Martin Nugent  
01254 828060  
D3/12/0055

Drafted 22 March 2012

**Planning Applications, Ribble Valley District  
3/12/0055 Ash Lea, Whalley Road, Pendleton**

DRG TITLE Proposed Plans (Planning)

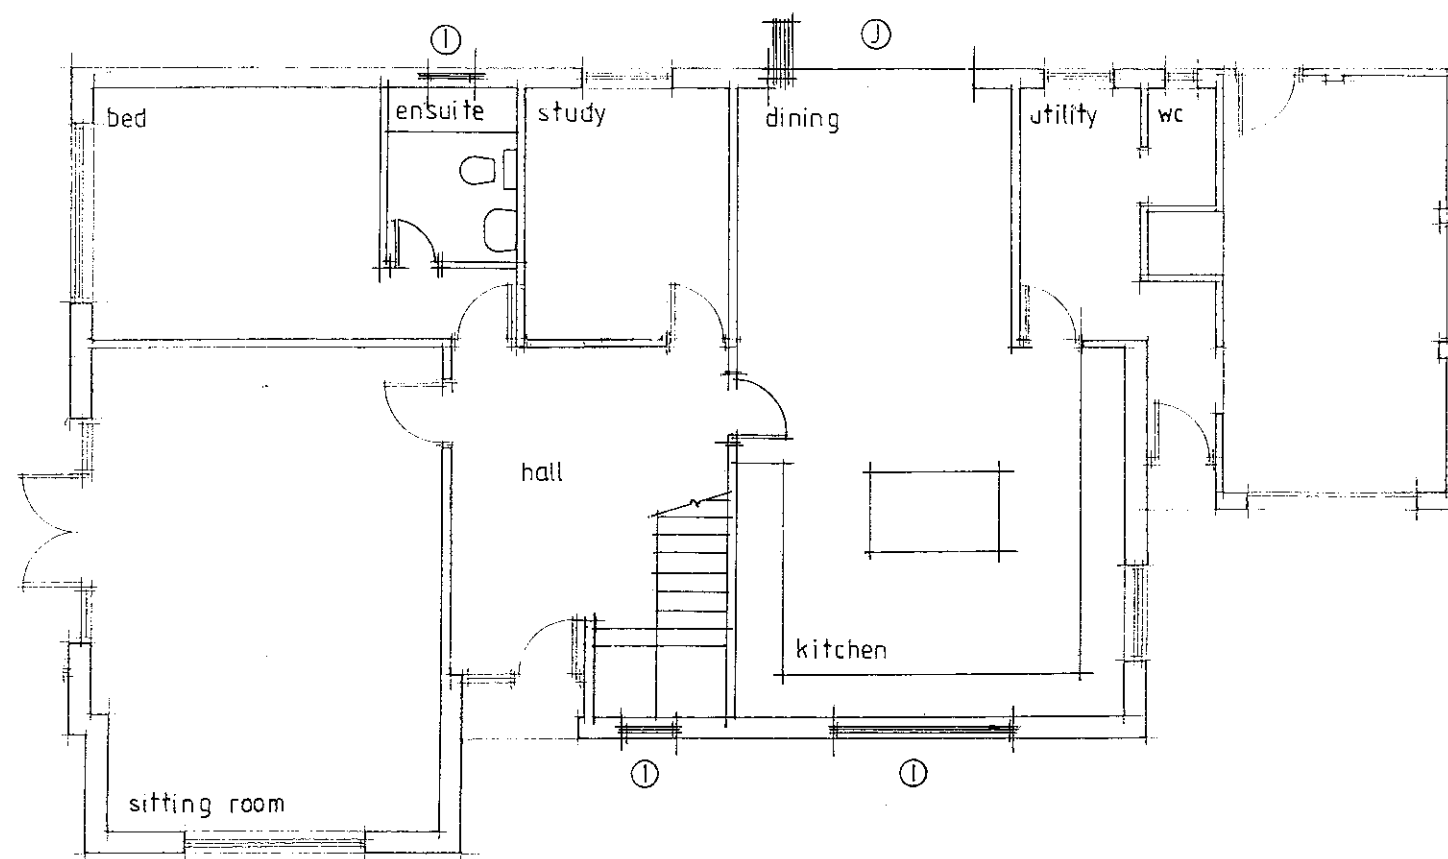
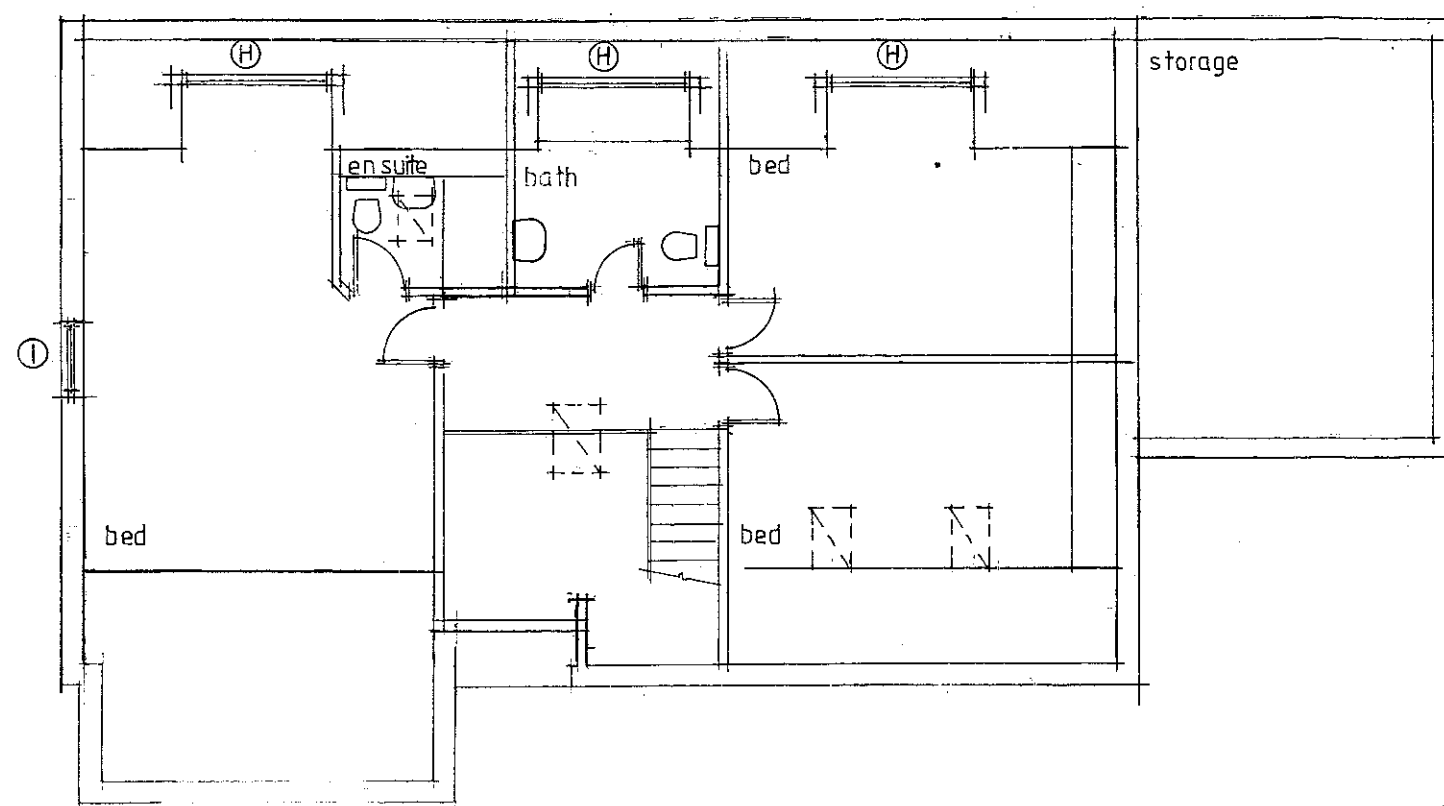
In my email reply of 12 March I noted that I had no objection to the proposed application on highway safety grounds as the application identifies sufficient off street parking for three vehicles, one within an integral garage and the remaining two on land within the property curtilage.

Further to this, I would recommend that a Condition be attached to any successful application that seeks to retain the use of the garage for their intended purpose and to prohibit its future conversion to residential living space.
